Item No. **Report of the Head of Planning, Transportation and Regeneration**

Address PEMBROKE HOUSE 5-9 PEMBROKE ROAD RUISLIP

Development: Erection of detached building to accommodate office accommodation above existing parking.

LBH Ref Nos: **38324/APP/2019/4066**

| TITLE   | Proposed Site Layout                                                                   |             |          |

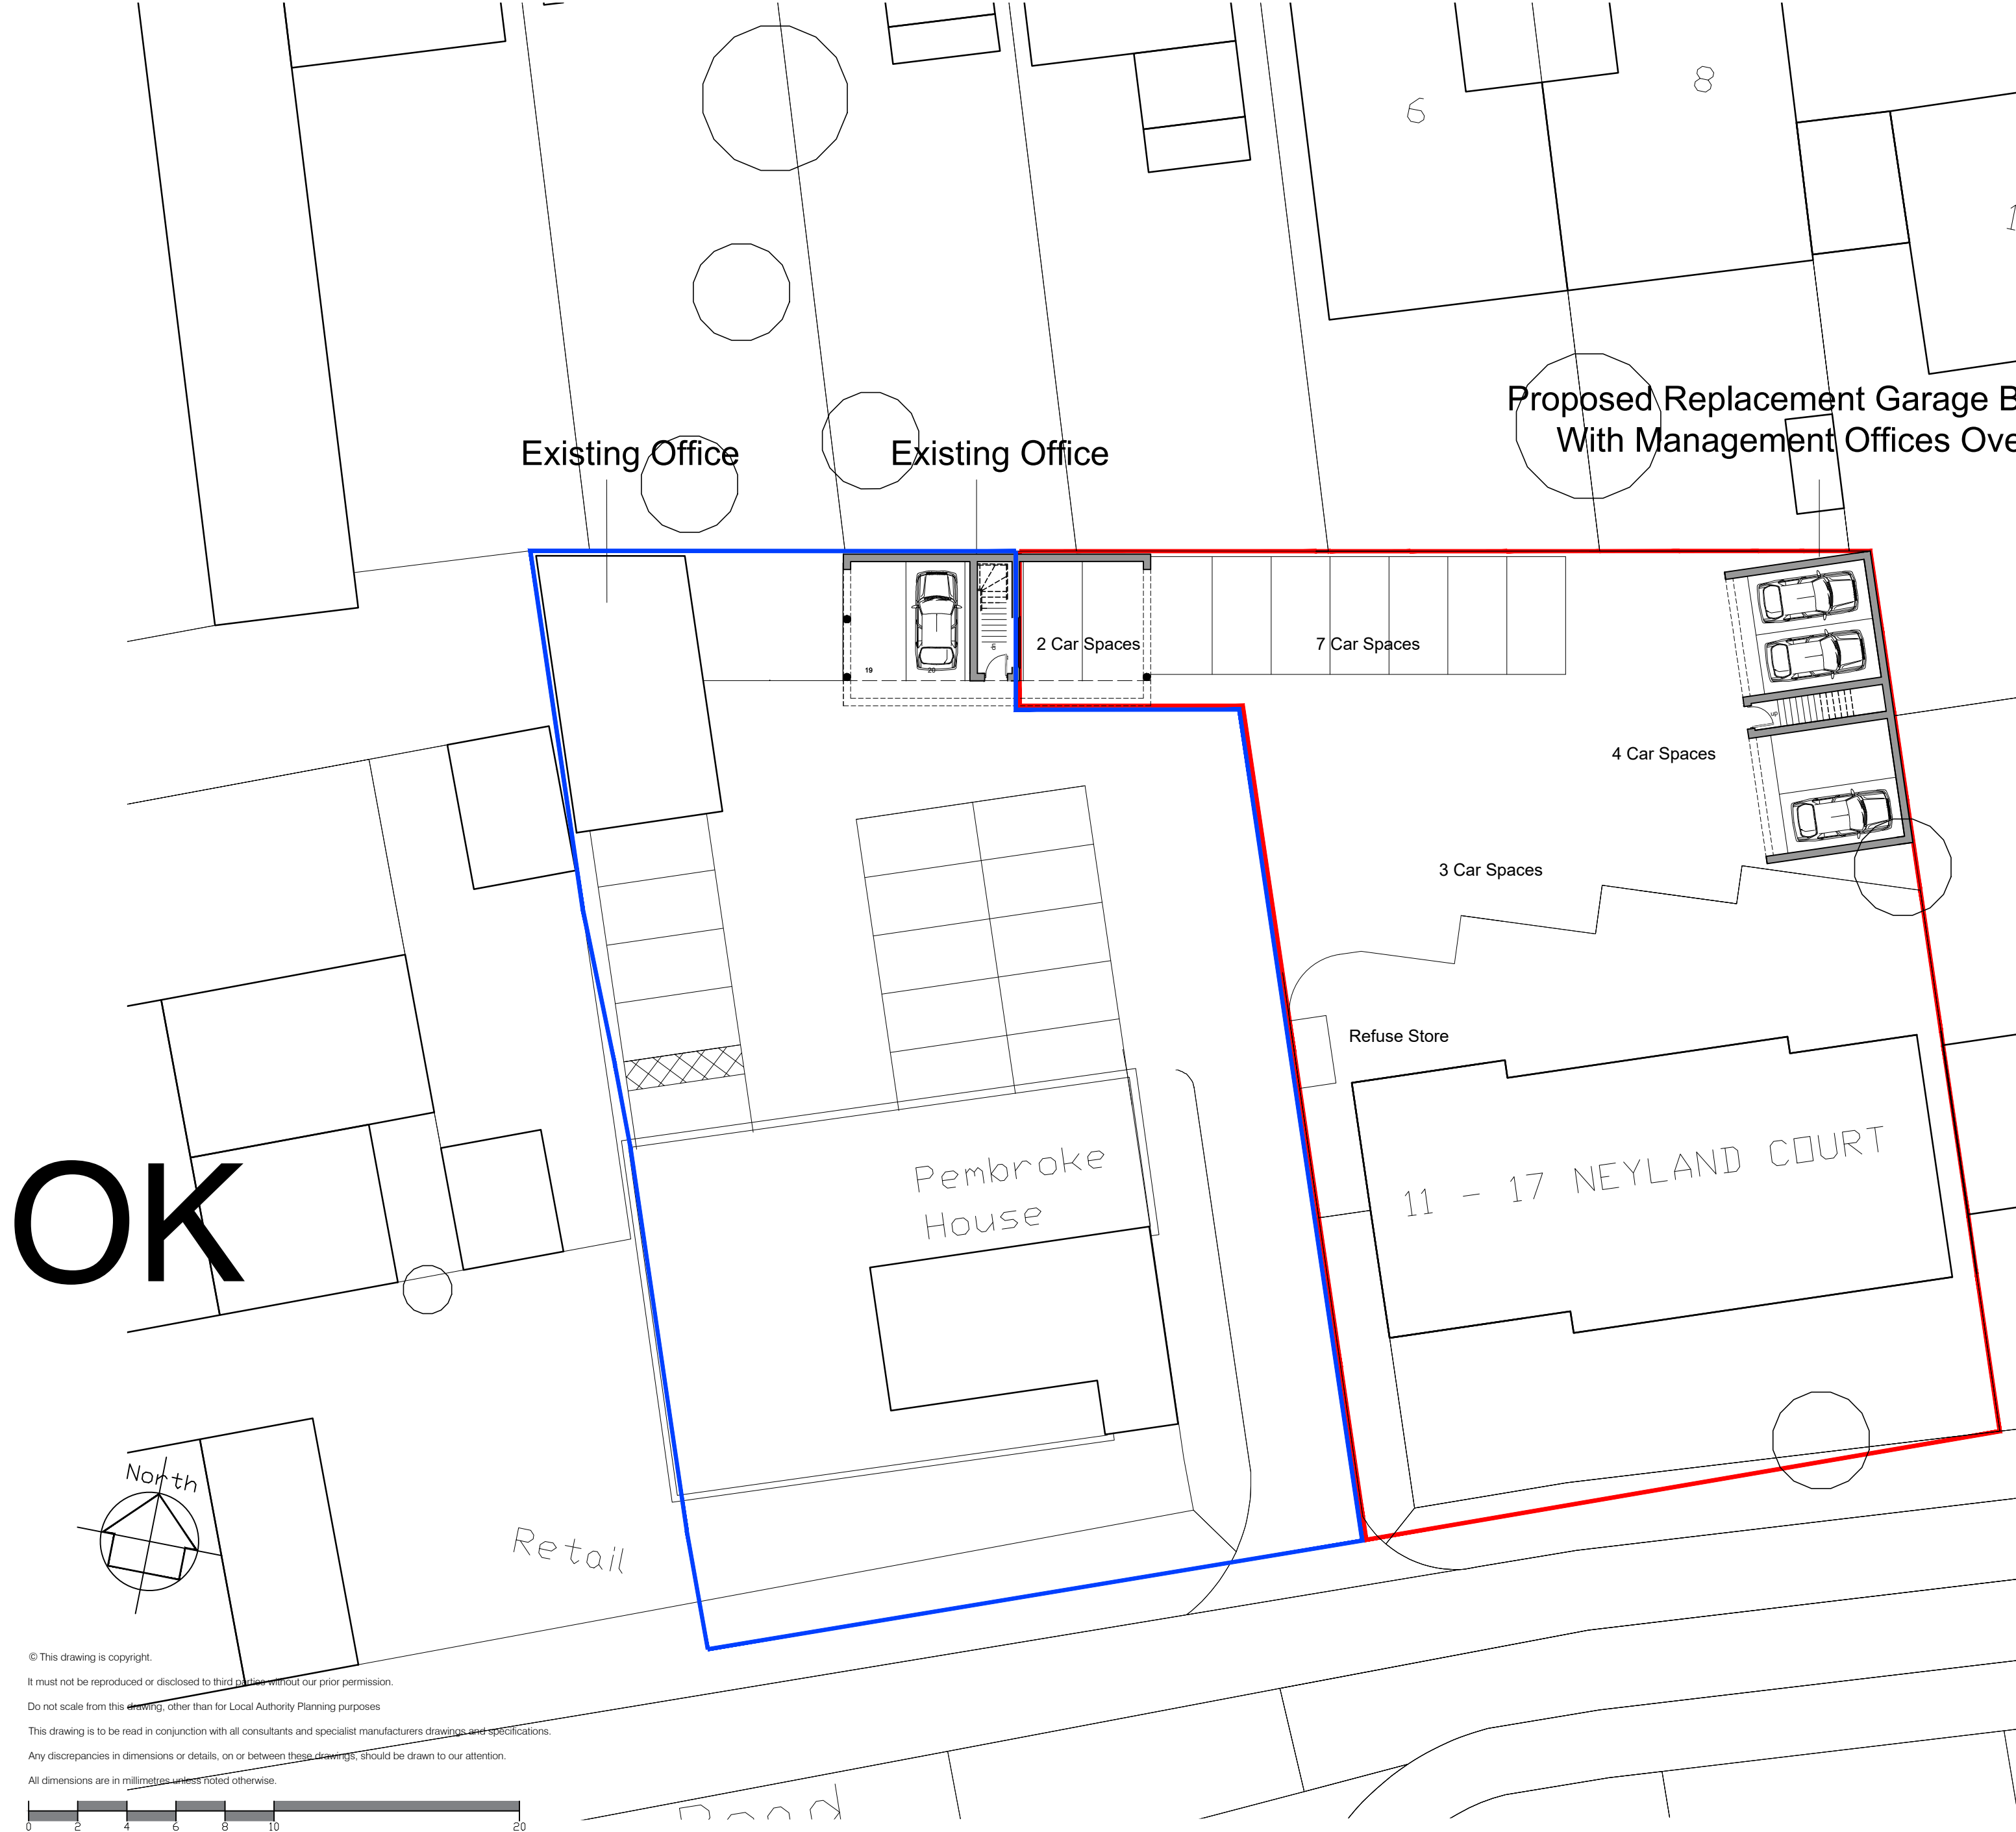
The new position of the proposed building would be set above three parking spaces (19-21). Parking spaces Nos. 17 and 18 would remain in situ. Four parking spaces would be provided within an undercroft garage namely Nos 19 to 22

As there would be one additional parking space provided (22) and the existing parking spaces Nos 17 and 18 would remain as at present and usable, the proposal is considered to comply with the Appeal Decision and Policies DMT 1, DMT 2 and DMT 6 of the Hillingdon Local Plan: Part Two - Development Management Policies (January 2020)

The car parking to be provided with the development hereby approved shall be kept available for the parking of vehicles at all times.

Proposed - Elevations

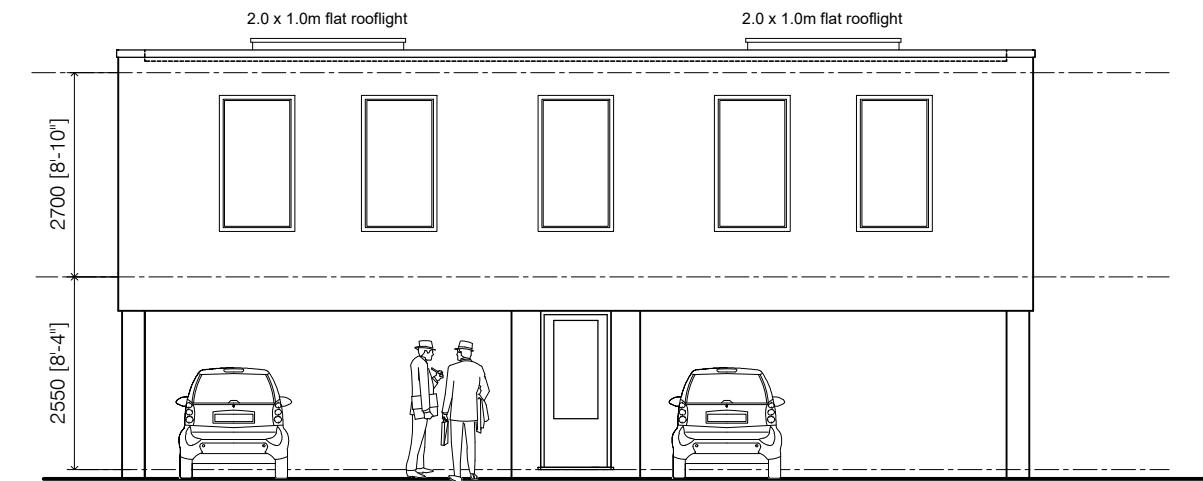
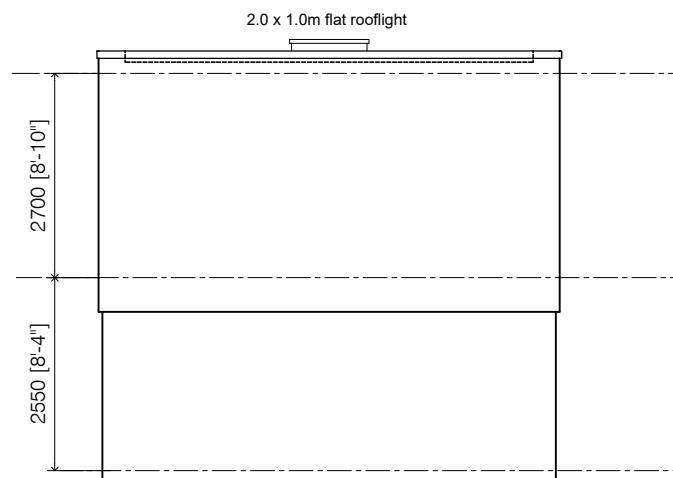
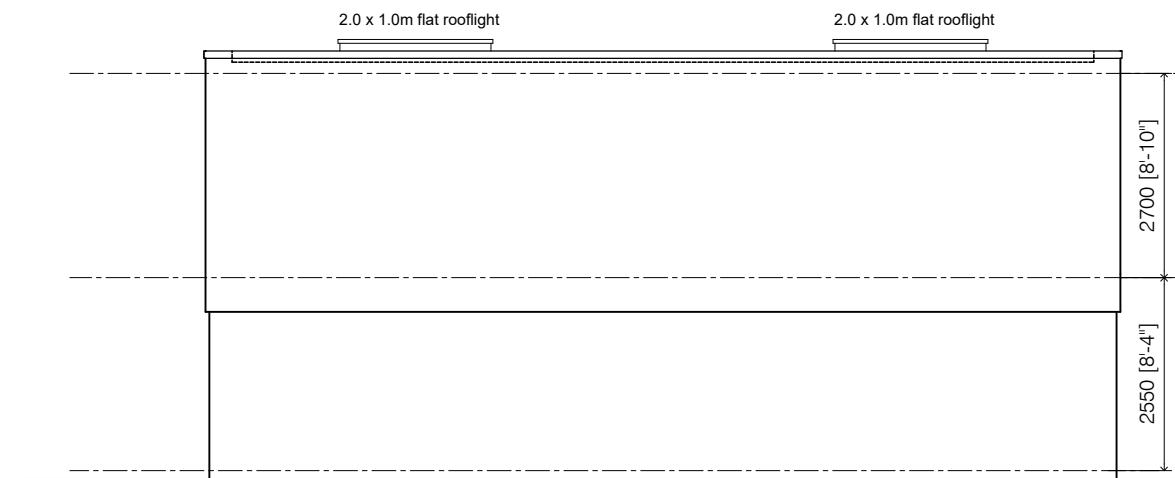
The proposal would provide three tilt and turn windows at first floor level on the front elevation and two smaller top hung casement windows in the two side elevations. No windows are proposed in the rear elevation at first floor level. The side window on the eastern elevation would face onto garages at the rear of Neyland Court and so would not result in overlooking or loss of privacy. The window on the western side elevation would face onto the existing office building. Given the 6m distance between the two buildings, there could be an issue of overlooking of windows of the existing and proposed offices; the proposed side window would therefore need to be obscure glazed so that there would not be an issue of overlooking of the two office buildings. The orientation of the existing and proposed buildings would not have a significant impact on daylight/sunlight provision to the buildings.

The first floor side window(s) in the western elevation shall be glazed with permanently obscured glass to at least scale 4 on the Pilkington scale and be non-opening below a height of 1.8 metres taken from internal finished floor level for so long as the development remains in existence.
